## **Ecology Response to EIA Scoping Requests**

**Ribble Valley Borough Council Planning  
Applications 3/2019/0977 and 3/2019/0981**

**EIA Scoping request for the installation of tunnelled pipework at the  
Bowland Section of the Haweswater Aqueduct and associated works  
(3/2019/0977)**

**John Jones  
Senior Ecologist  
Environment Team  
Design & Construction Service  
Lancashire County Council**

**FIGURE 9.3**

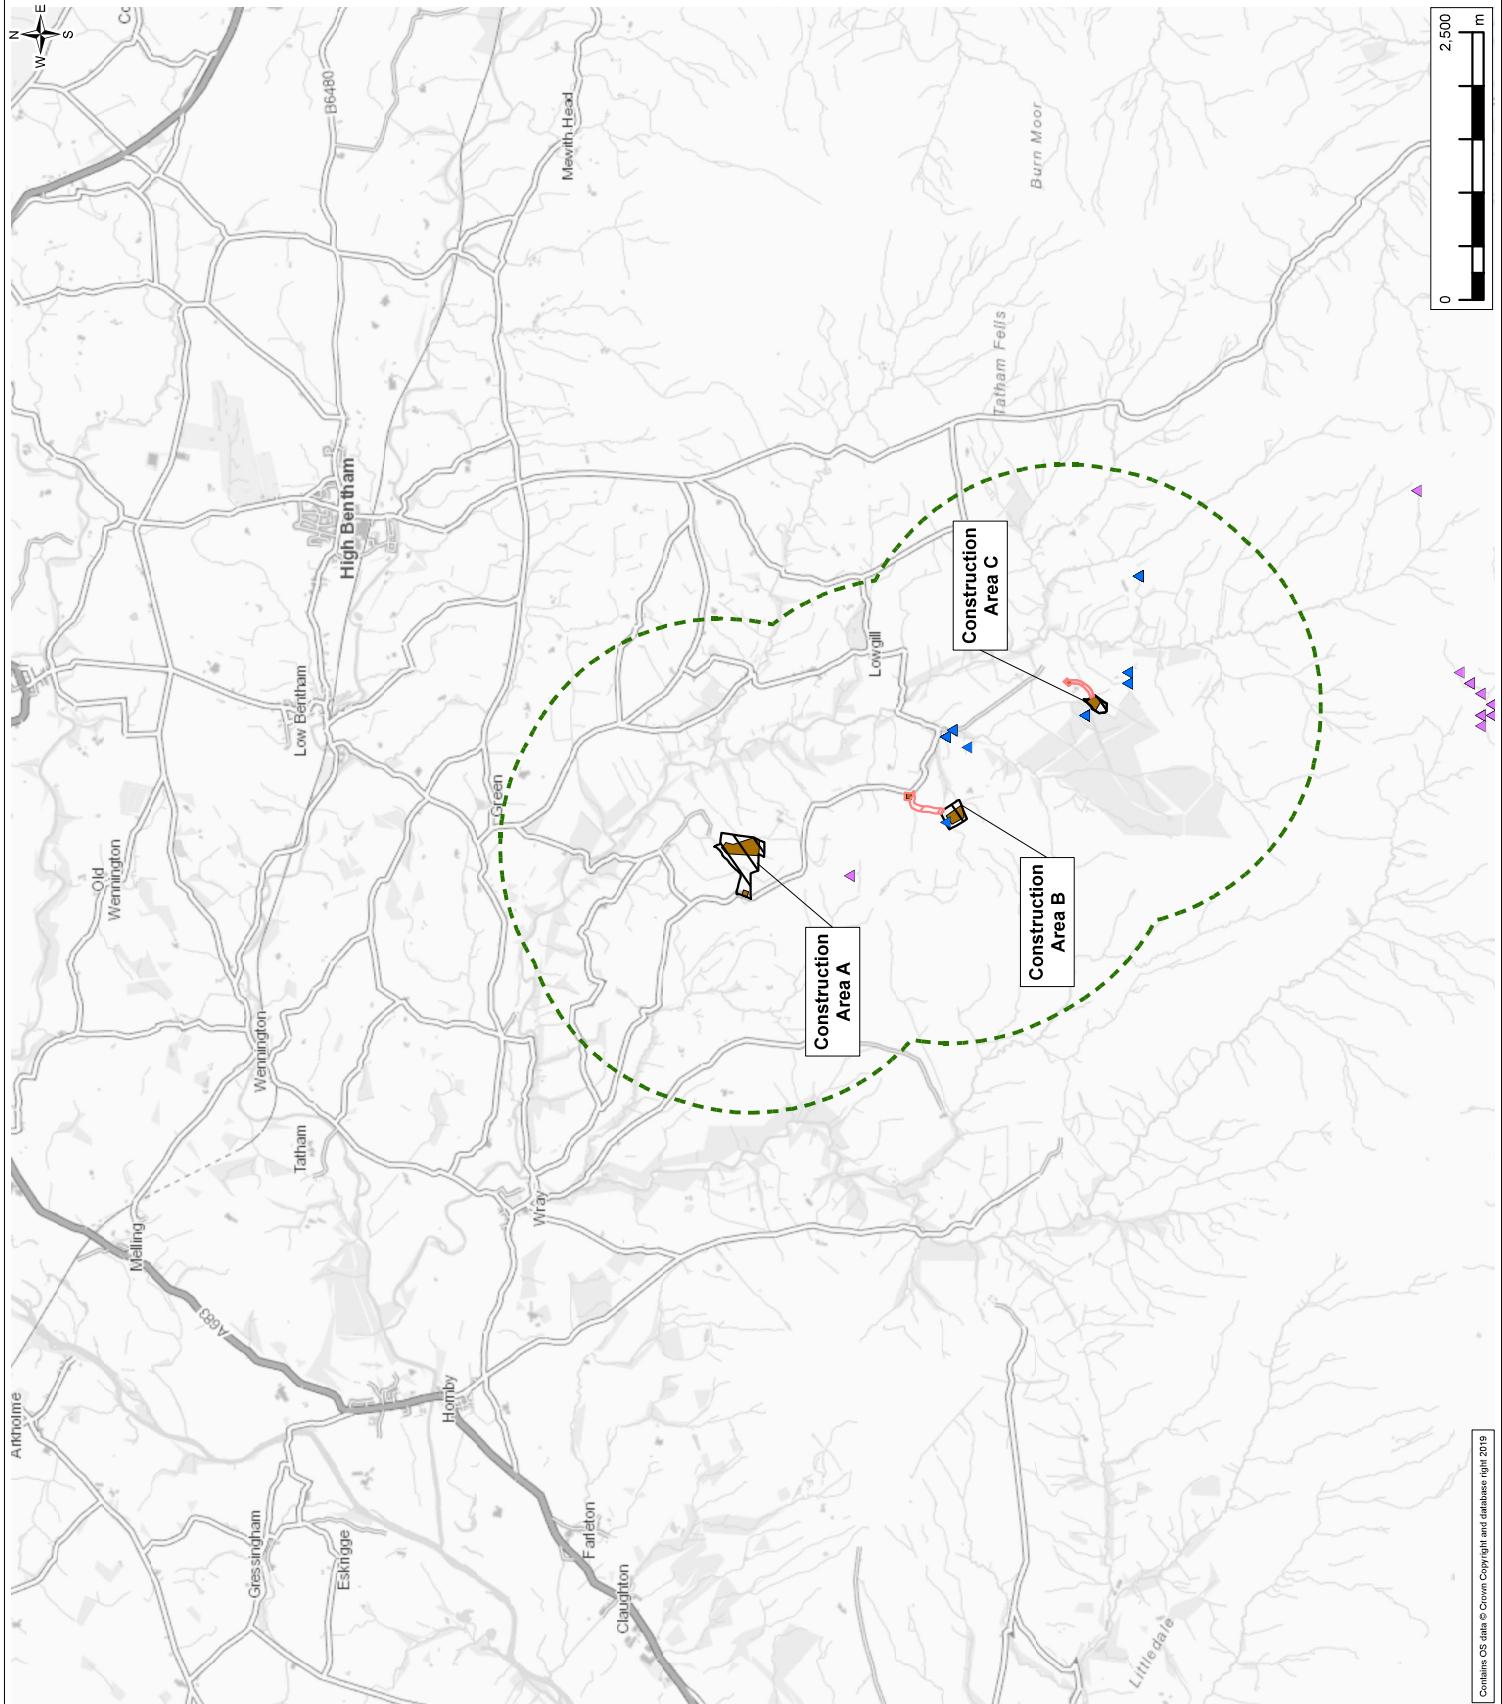
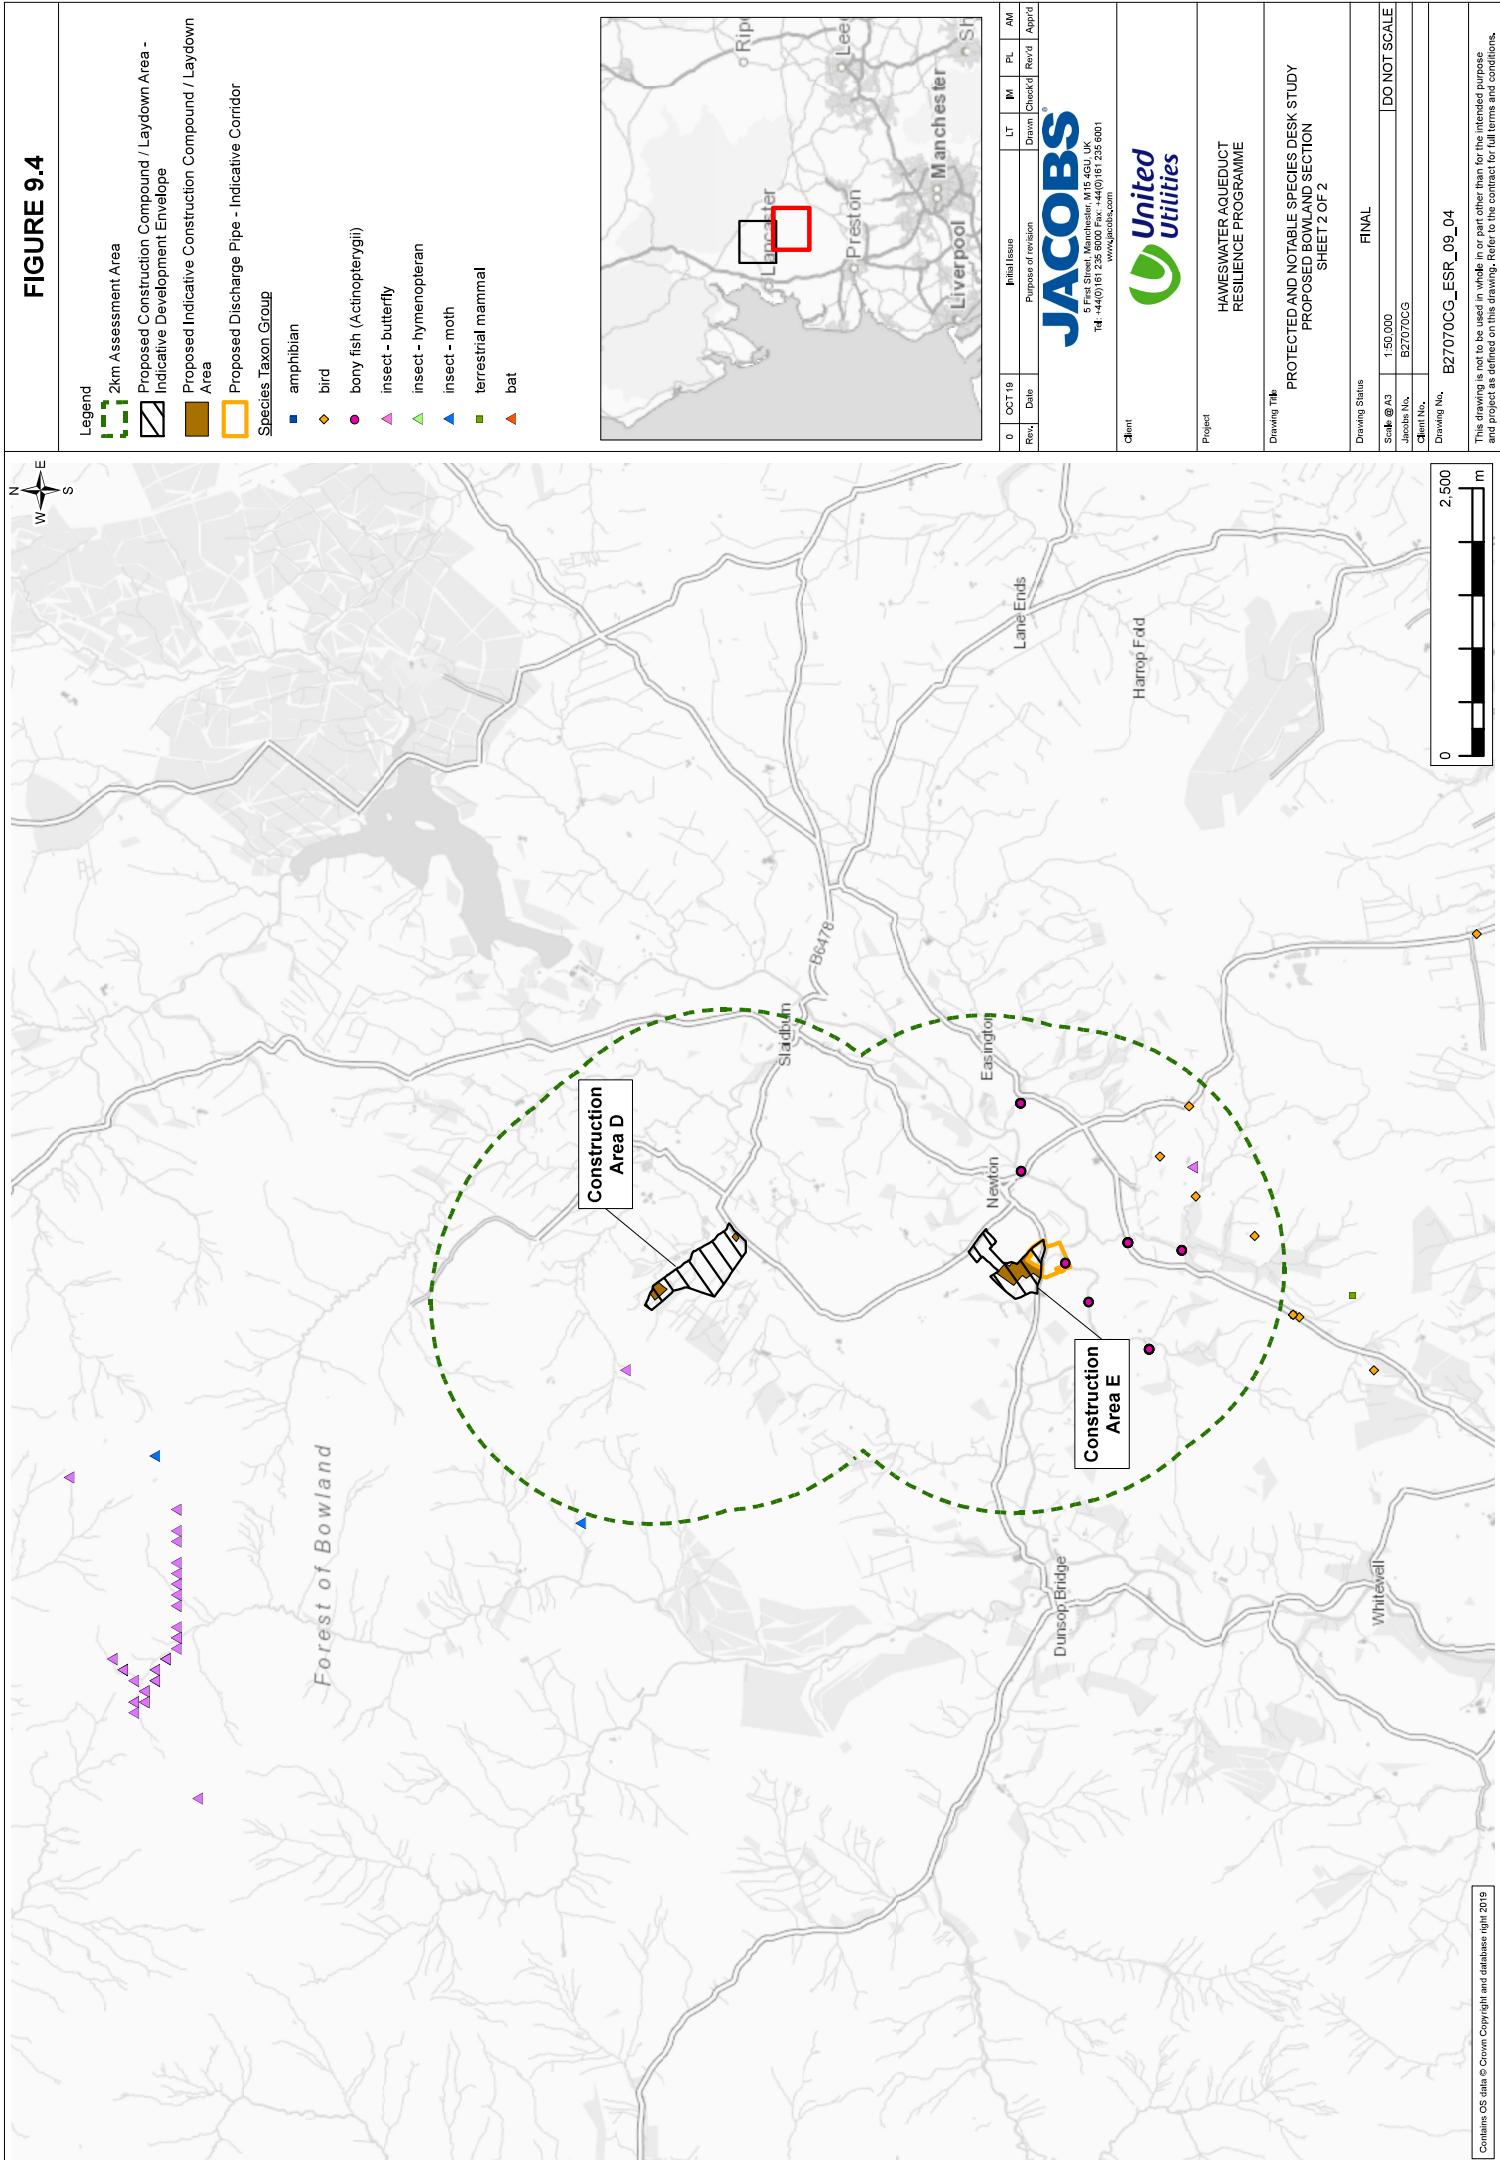
Each ES should address likely direct or indirect impacts on Biological Heritage Sites or other non-statutory designated sites. Figure 9.3 of both scoping reports illustrates construction areas impinging on Biological Heritage Sites. Impingement onto Biological Heritage Sites should be avoided and it should be demonstrated how impacts on Biological Heritage Sites will be avoided during and after the proposed development. To minimise the likelihood of impacts on a Biological Heritage Site, during development work, or in the long-term, the ES should include proposals for retaining a substantial buffer zone of native habitats between the BHS boundary and the development area.
